DEPARTMENT OF PARKS AND COMMUNITY SERVICES

December 10, 2024

Subject: Flying Horse North Phase Filing No. 5 PUD Development Plan and Preliminary Plan Amendment, 2nd Submittal (PUDSP-24-005)

PUD PRELIMINARY PLAN MINOR AMENDMENT  
 LS PLAN

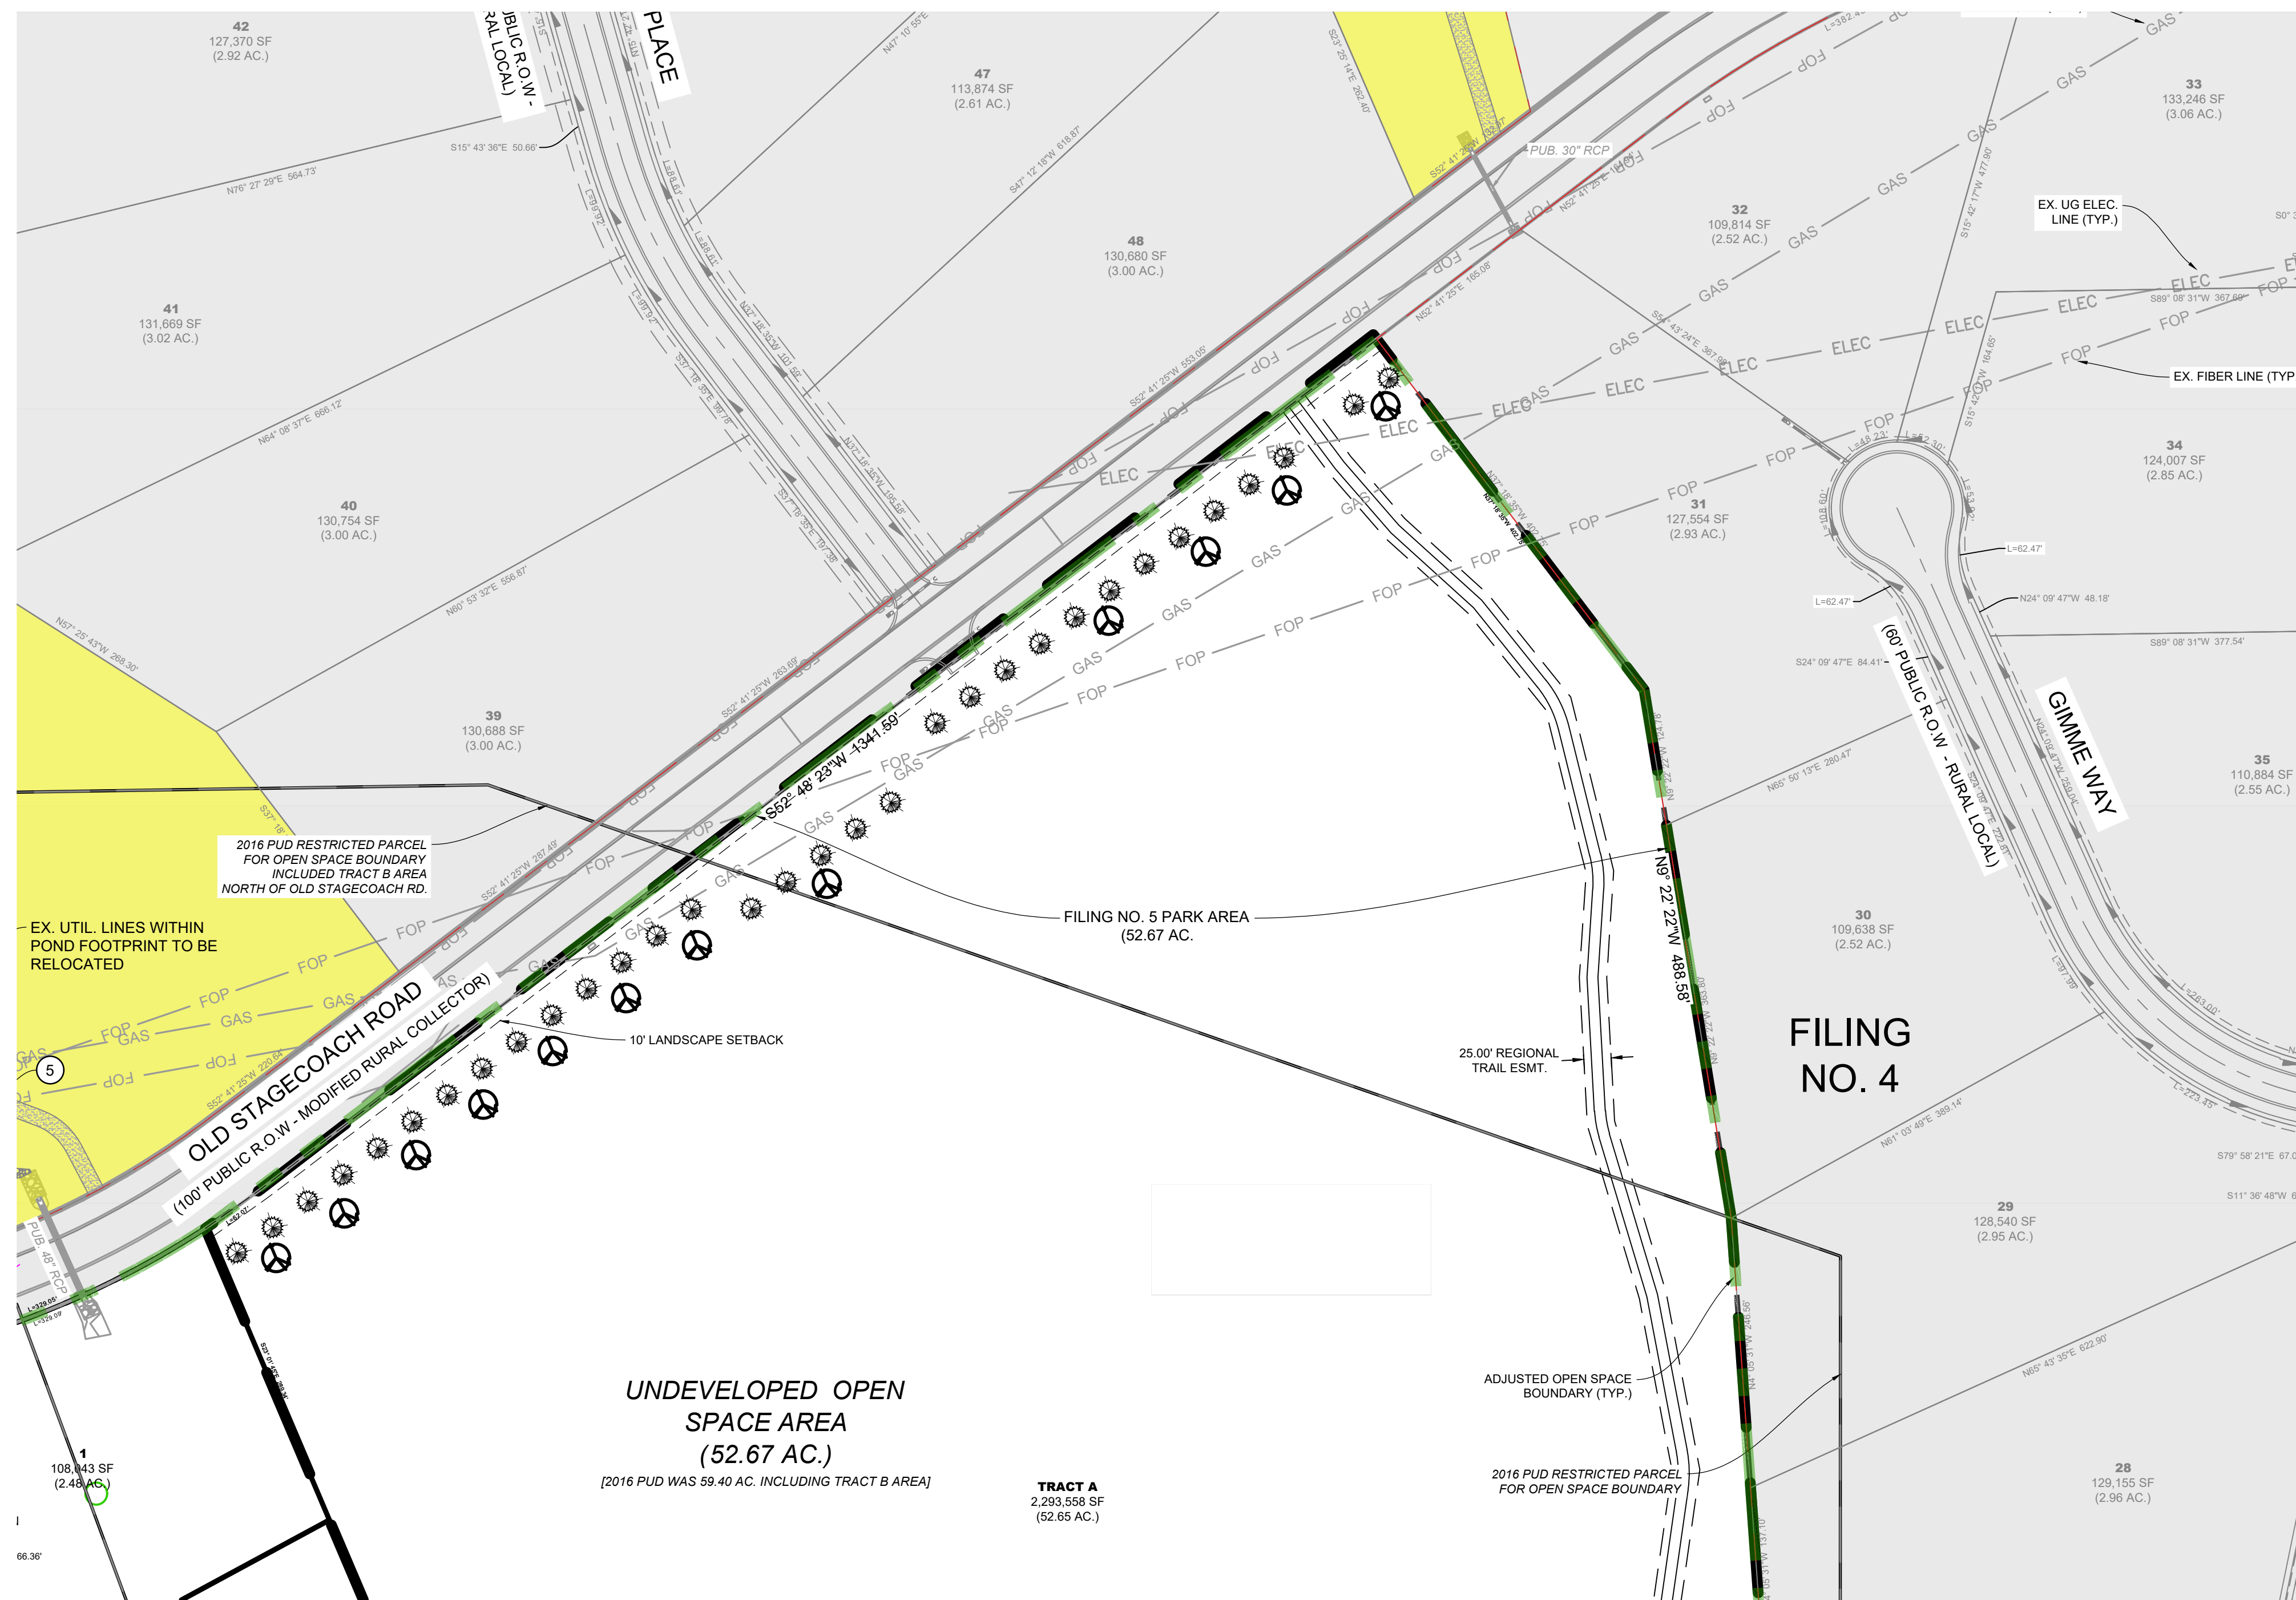
Although El Paso County Parks staff supports the general alignment of regional trail as shown in the Flying Horse North Trail Exhibit, staff continues to encourage the applicant to plan and develop a constructable and sustainable trail corridor in all future PUD Amendments and Final Plats. A well-planned trail alignment will allow for an easily constructable and maintainable trail in areas of rolling terrain, natural drainages, and other natural or manmade constraints, such as stormwater detention facilities and roadways.

Furthermore, and as shown in the 2022 El Paso County Parks Master Plan, the Fox Run Regional Trail does traverse the northern boundary of Flying Horse North, following the south side of Hodgen Road as it travels to the west. The current Flying Horse North Trails Exhibit does not show this alignment and instead terminates the trail when it reaches Hodgen Road. Staff recommends the applicant add this particular section of the Fox Run Regional Trail to all future plans and final plats.

The Park Advisory Board recommends that the Planning Commission and the Board of County Commissioners include the following conditions when considering and/or approving the Flying Horse North Filing No. 5 PUD Development Plan and Preliminary Plan Amendment: (1) add the missing section of the Fox Run Regional Trail conceptual alignment to the Flying Horse North Trails Exhibit, located along the south side of Hodgen Road, terminating at the northwesternmost corner of the development; (2) designate and provide to El Paso County 25-foot wide public regional trail easement through Filing No. 5 that allows for public access, as well as construction and maintenance by El Paso County of the Fox Run Primary Regional Trail, and the easement be shown, noted, and dedicated to the County via the forthcoming Final Plat; and (3) fees in lieu of land dedication for regional park purposes in the amount of \$10,605 will be required at time of the recording of the forthcoming Final Plat. A Regional Trail Agreement may be acceptable alternative to regional park fees, provided the agreement is submitted by the applicant, reviewed and approved by the County, and executed prior to recording the Final Plat."
